# Mitchells Way / Barnsley Road, Wombwell

Road Safety Audit  
Stage 1  
October 2018

Project No: 1386

Proposed Bus Stop Relocation

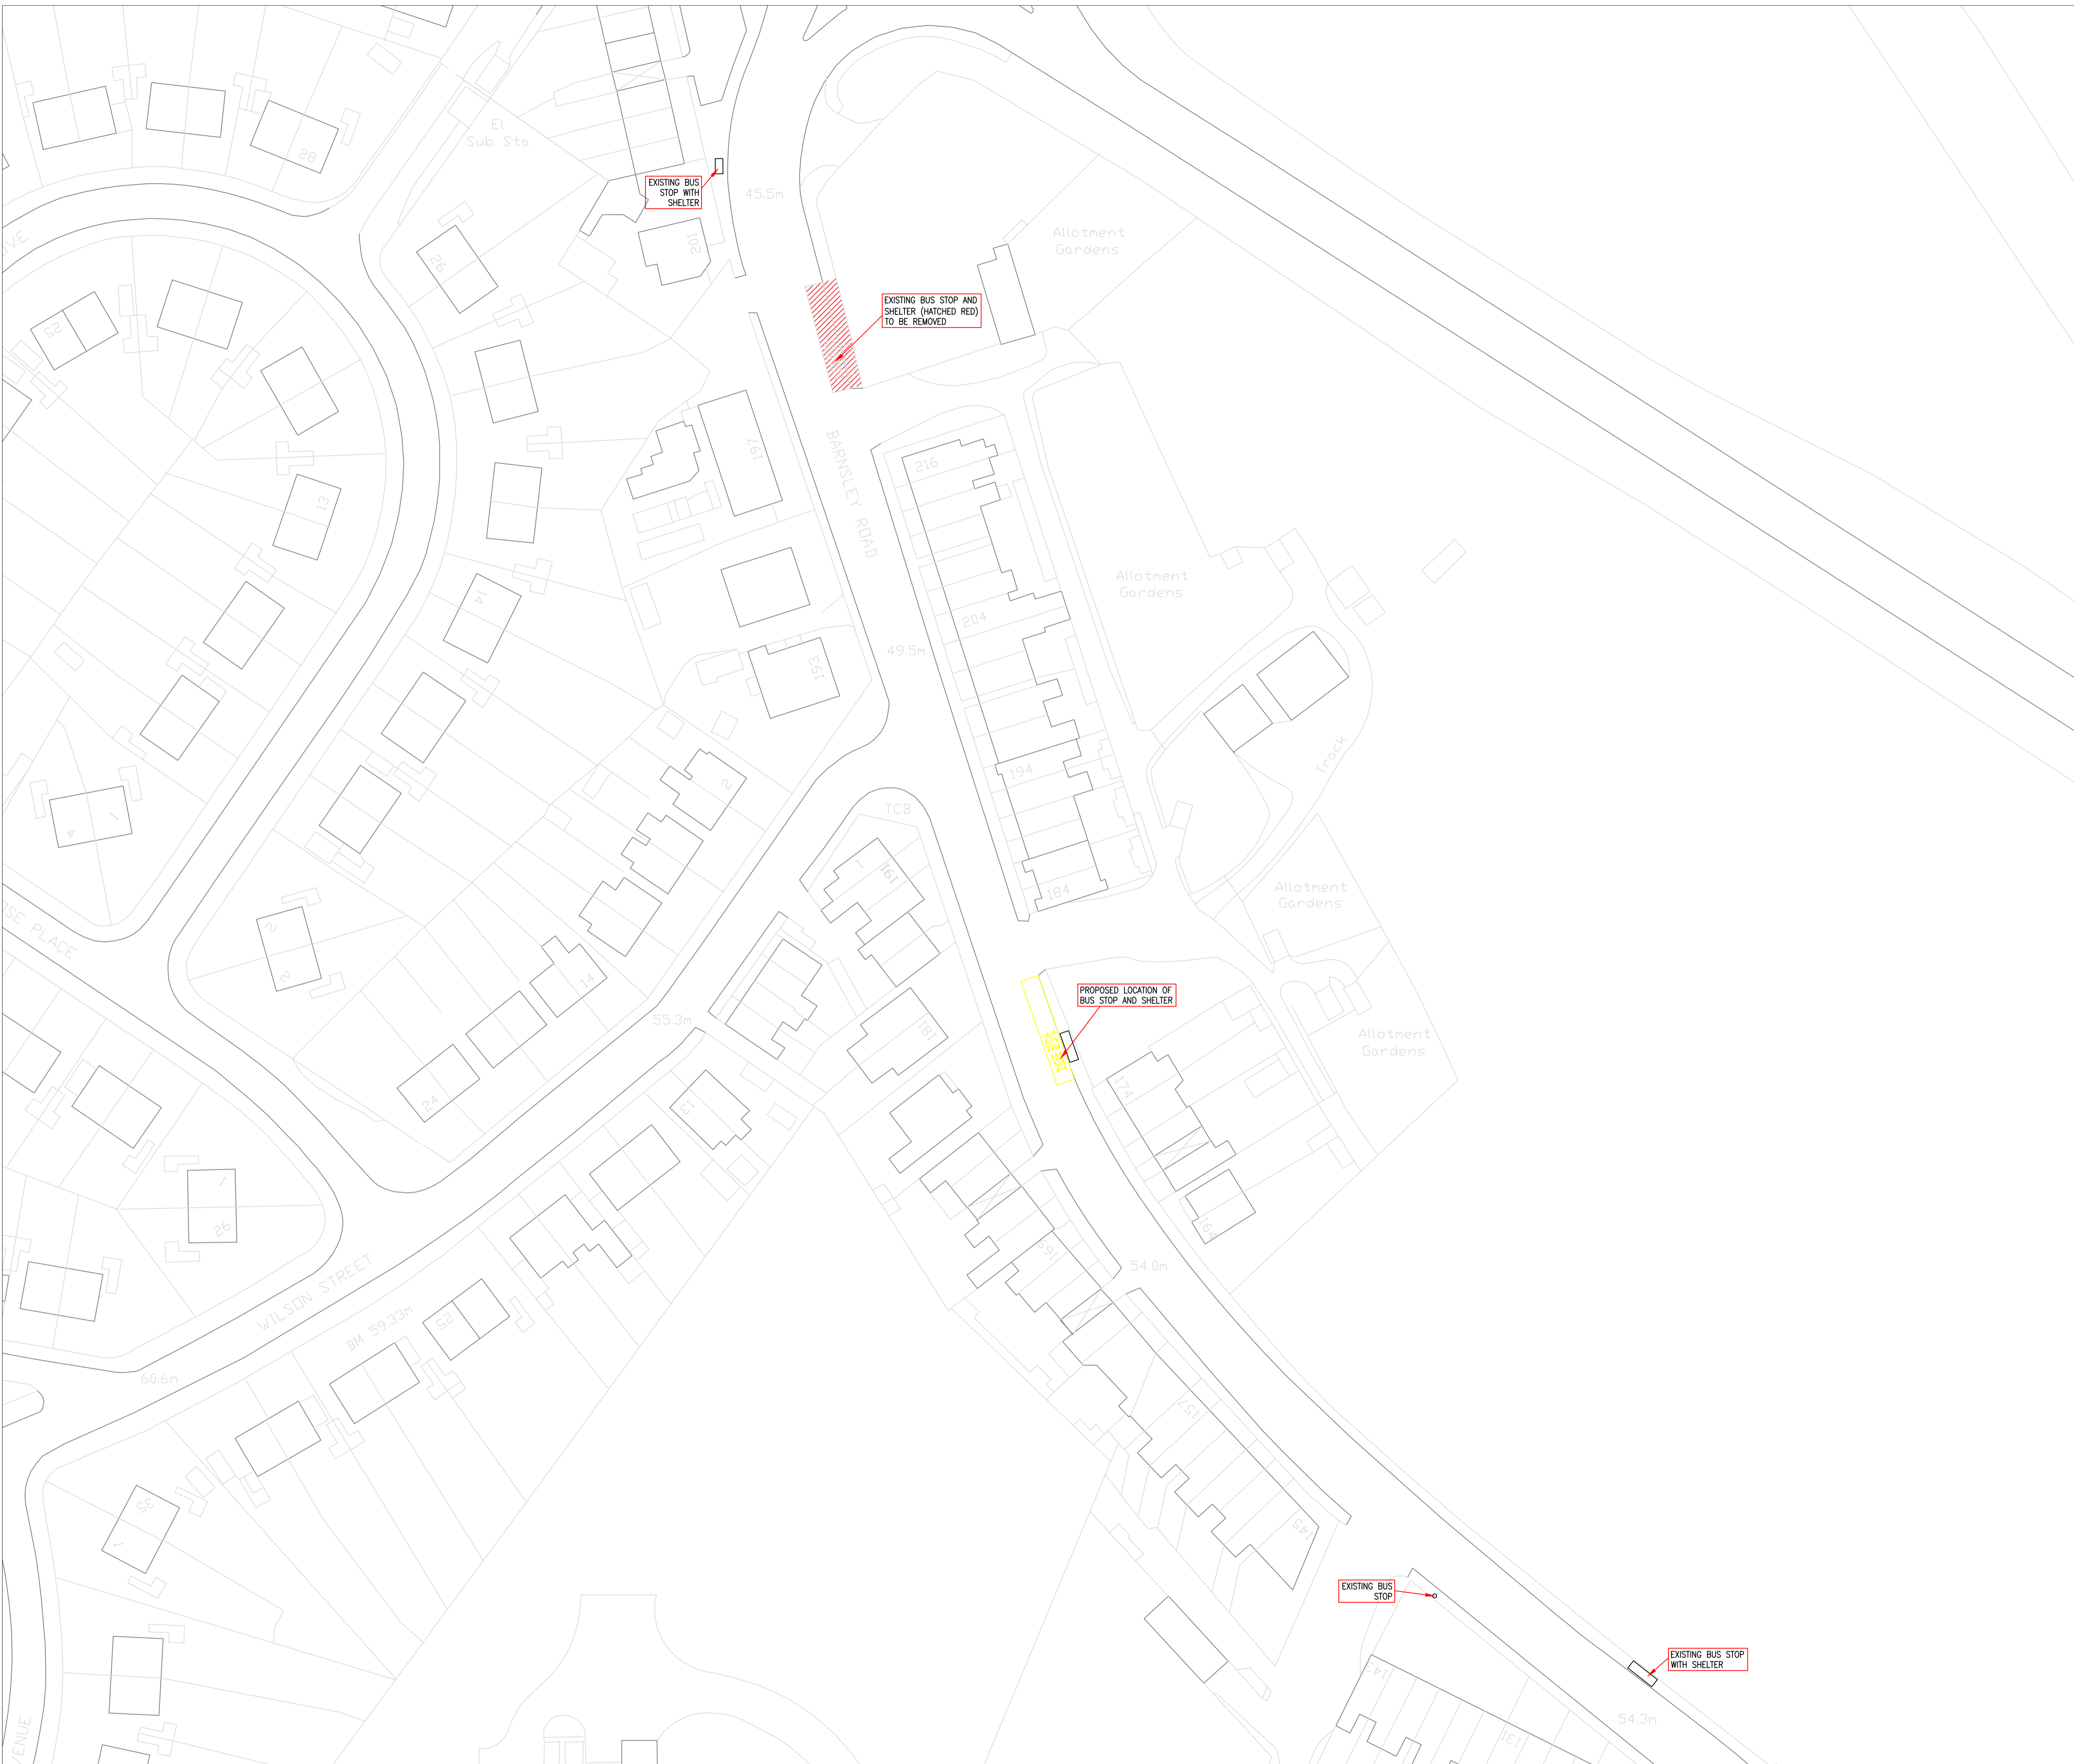
**Detail:** There is an existing bus stop and shelter (See Image below), located at the proposed location of the new access to the petrol station. There is no mention of the bus stop or shelter being relocated and if it remains in its present position could obstruct movement to and from the access and obstruct sightlines creating a potential hazard for egressing vehicles.

**Recommendation:** Relocate the bus stop & shelter to a more suitable location.

13.6m OIL TANKER
OVERALL LENGTH 13.600m
OVERALL WIDTH 2.500m
OVERALL BODY HEIGHT 2.704m
MIN BODY GROUND CLEARANCE 0.419m
TRACK WIDTH 2.450m
LOCK TO LOCK TIME 4.00s
KERB TO KERB TURNING RADIUS 6.670m

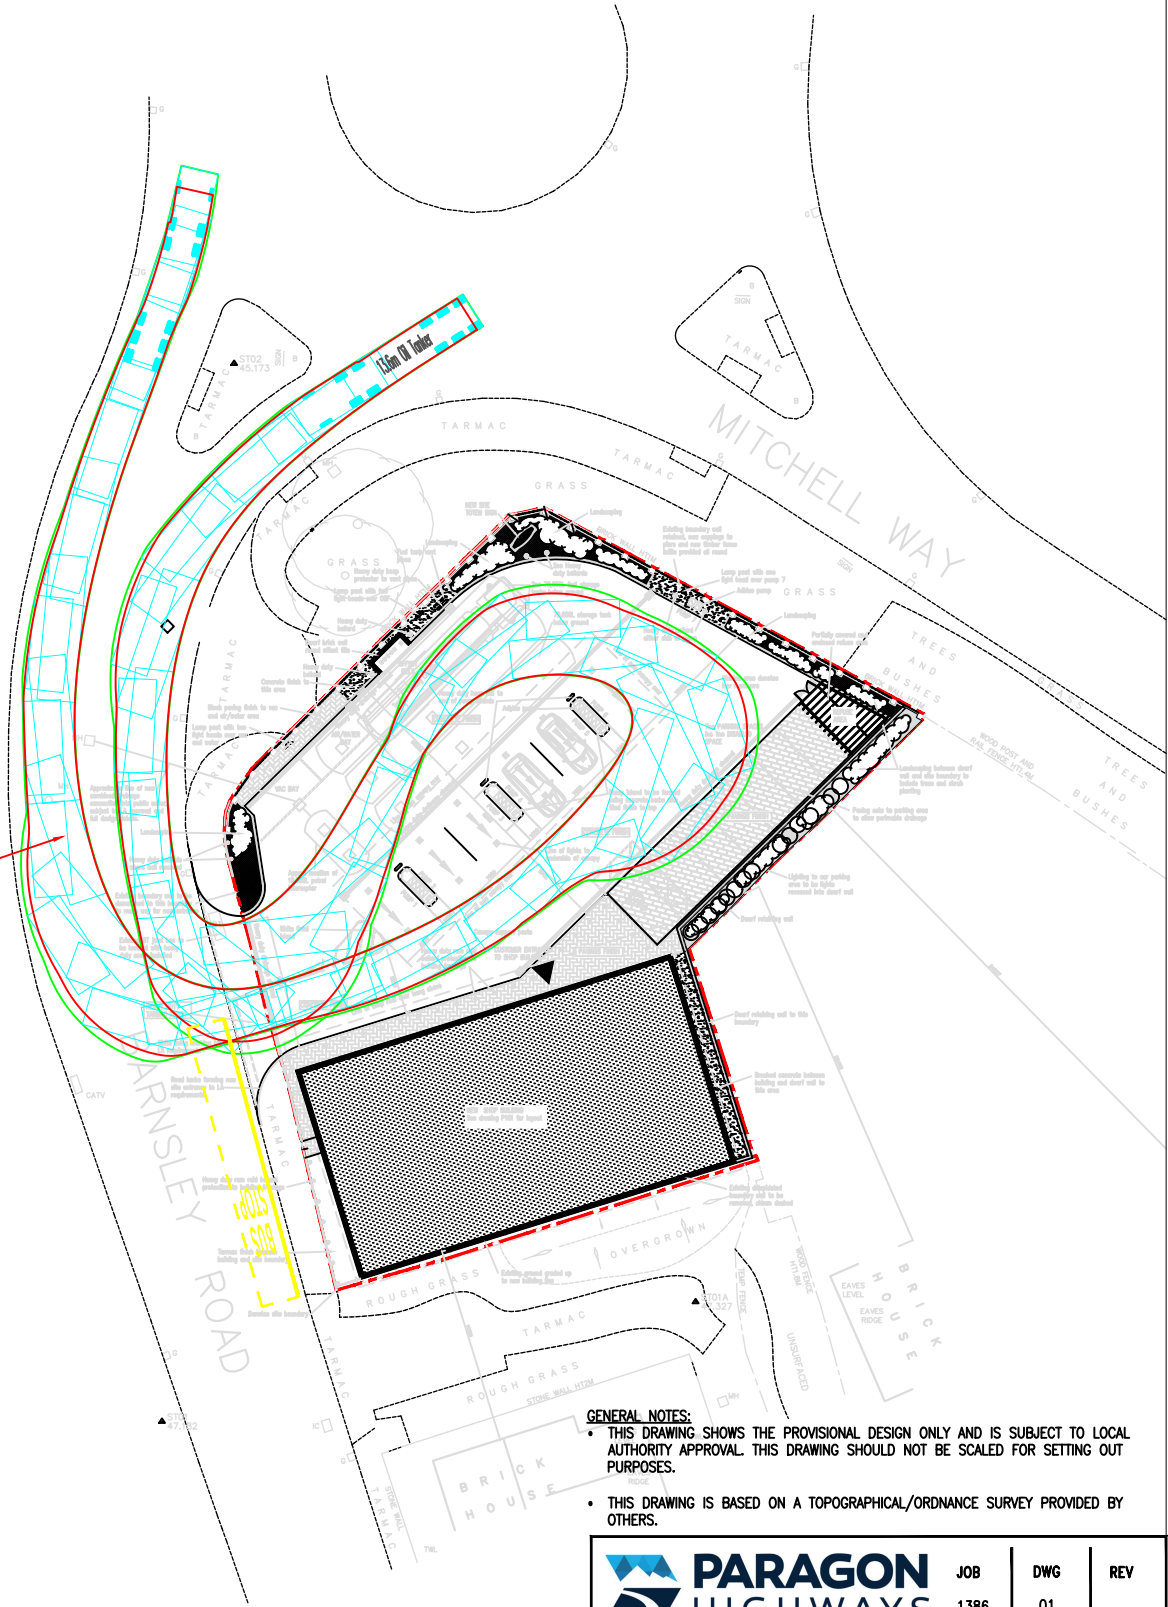
**Detail:** The swept path shown for the oil tanker appears to be tight and with potentially limited room for driver error.

**Recommendation:** Ensure that all types of vehicle expected to use the forecourt can turn and manoeuvre safely within the area without conflict with other vehicles or physical feature within the site.
